DECISION DELEGATED TO HEAD OF PLANNING

Application No:	H09-0619-22	Applicant:	Ashwood Homes
Proposal:	Details of means of surface water disposal, landscaping & biodiversity strategy, tree protection during construction works, boundary treatments, management plan for publicly accessible open space & outdoor play areas, written scheme of archaeological investigation, FRA (ffl), surface water disposal, estate road & associated footways, estate road phasing & completion plan, details of construction management, precautions for prevention of mud deposits on public highways, external materials and notice confirming requirement for water consumption (Conditions 3, 4, 5, 6, 7, 8, 9, 11, 12, 13, 14, 15, 16, 17, 18 & 19 of H09-0784-21)		
Location:	Land Off Fen Road Holbeach Spalding		
Terminal Date:	17th August 2022

PROJECT:	Proposed Residential Development at Fen Road, Phase 2		
DRAWING:	Tree Protection Plan		
SCALE:	1:500@A1	DRAWN:	GP
DATE:	MAY.2022	REVISION:	-
DRAWING No:	127-TP-01

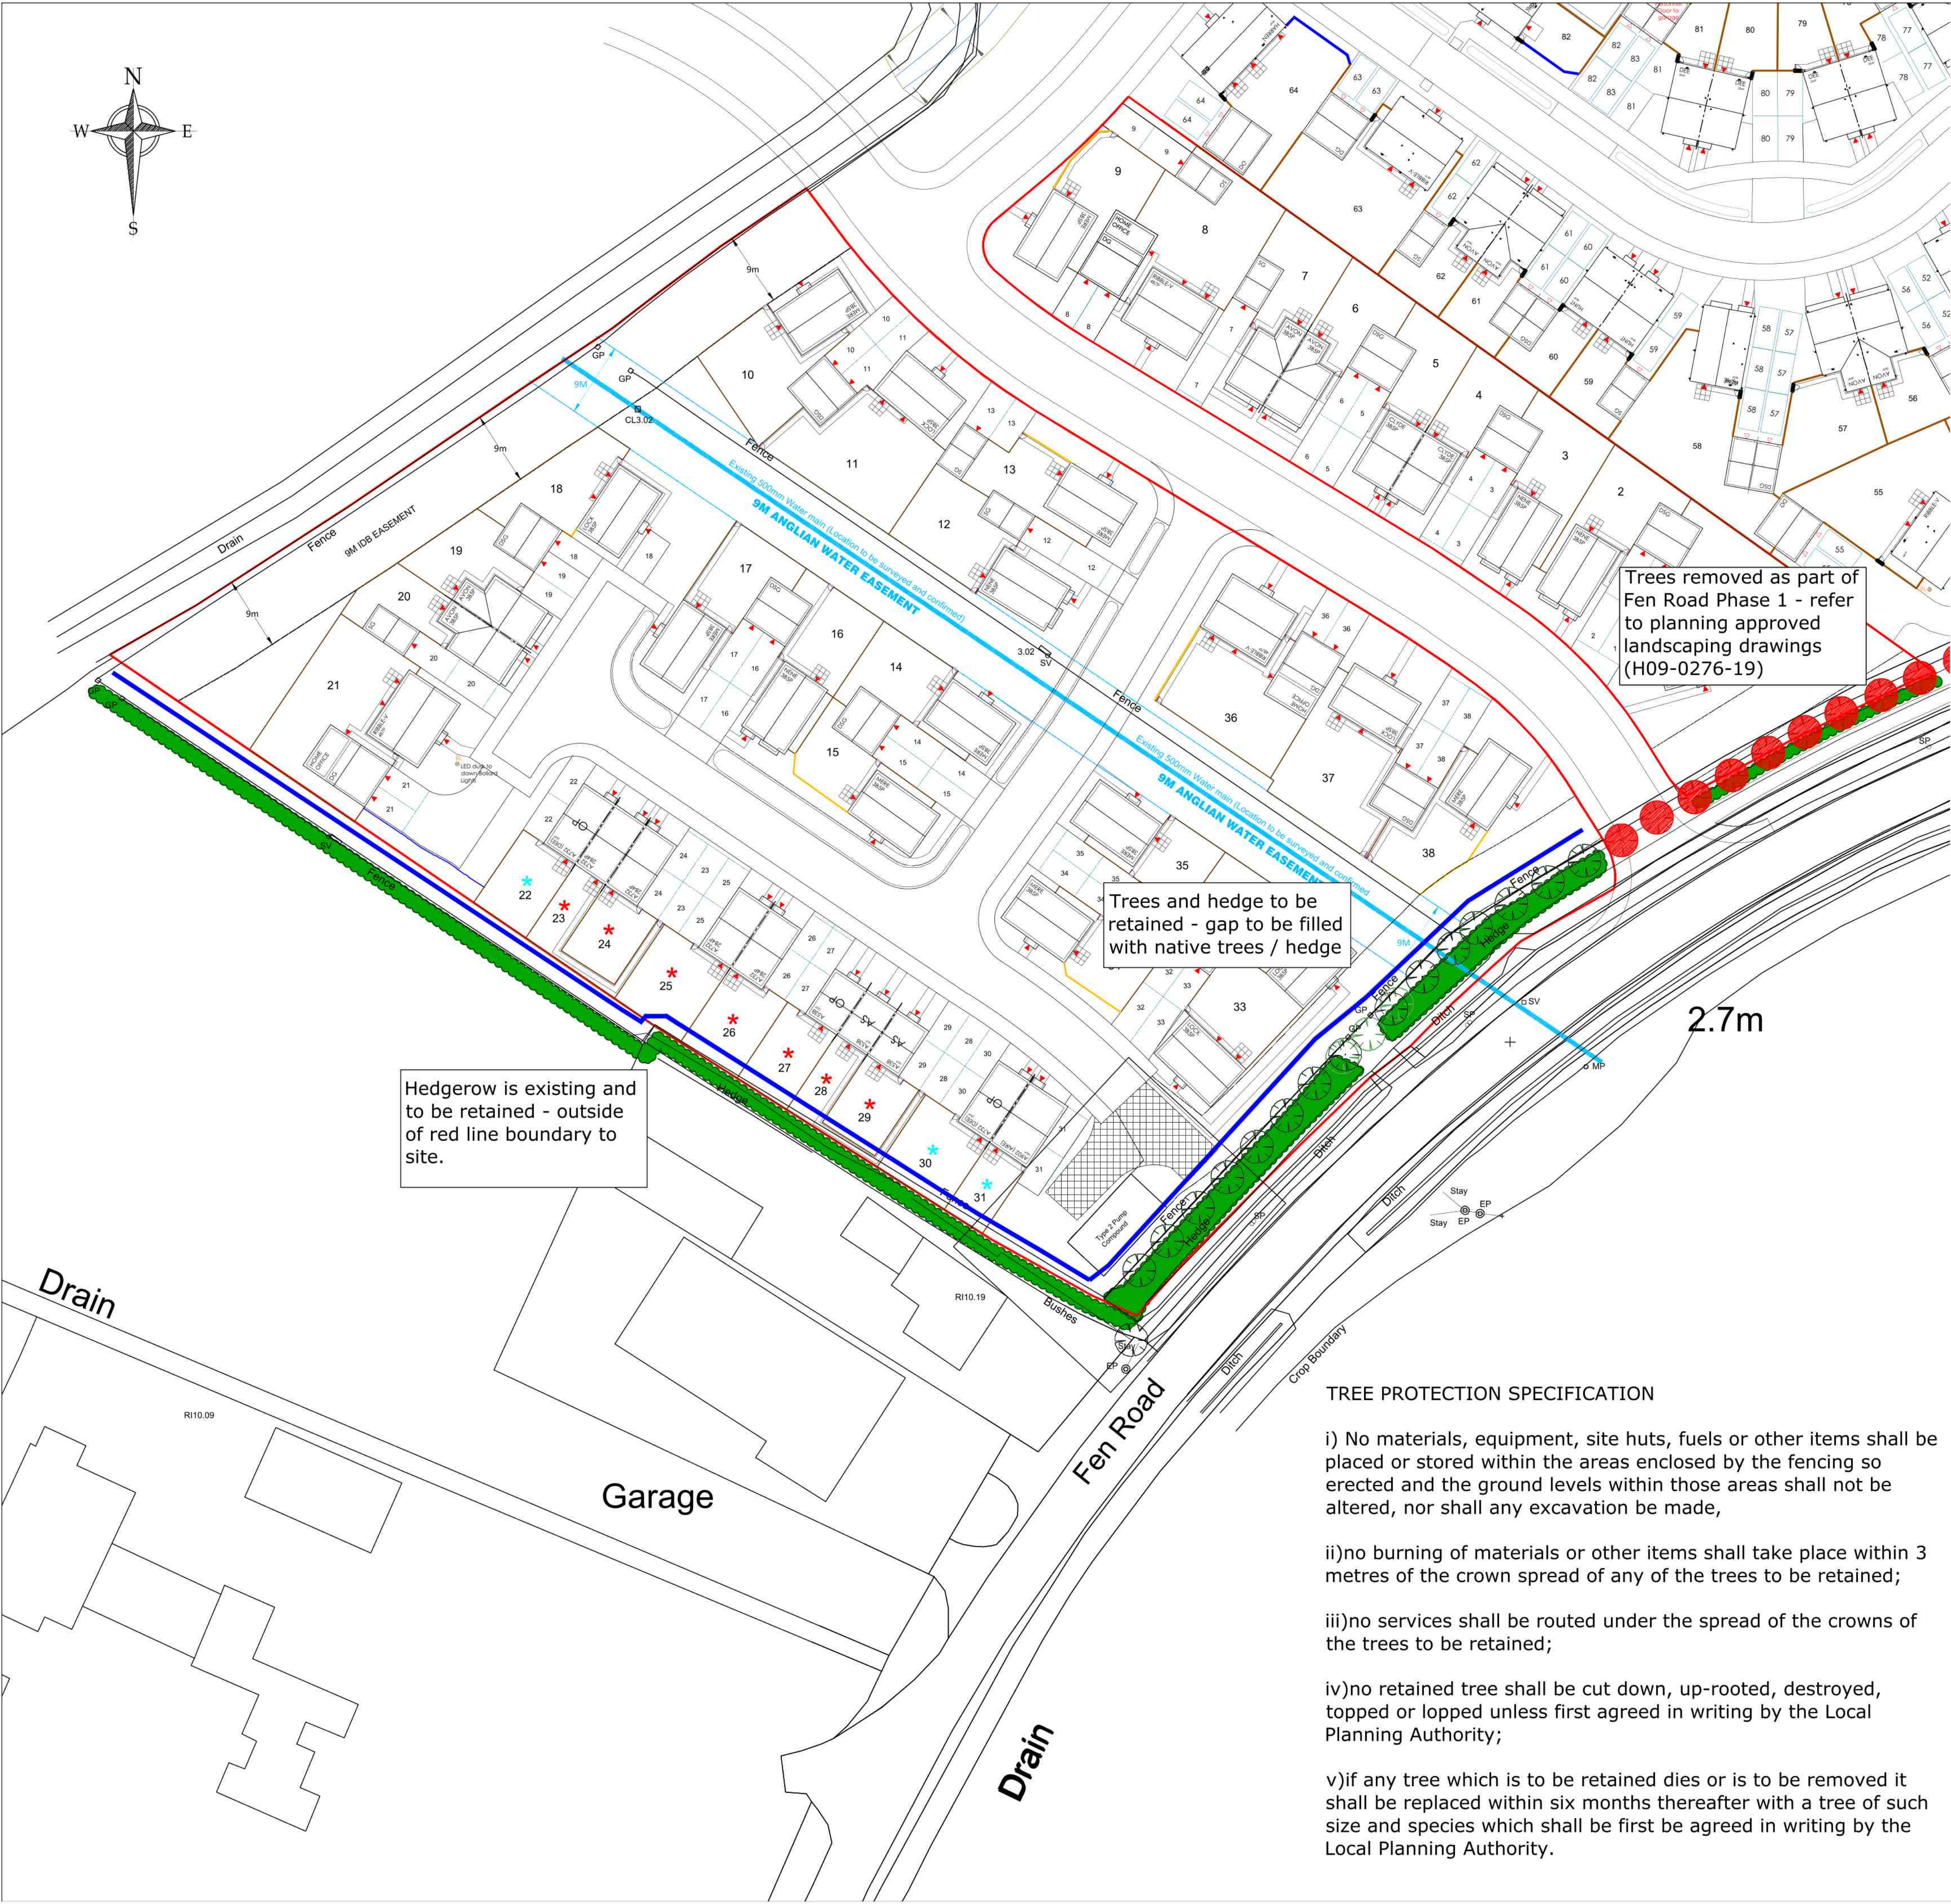
Regarding the additional information, question why existing trees and hedge to north east of entrance were removed if they are then going to replace them.

The SHDC Trees and Nature Conservation Officer questions why some trees have been removed to be replanted, however the removal of the trees was consented previously and this is now an improvement. Also, the trees are not covered by a TPO.
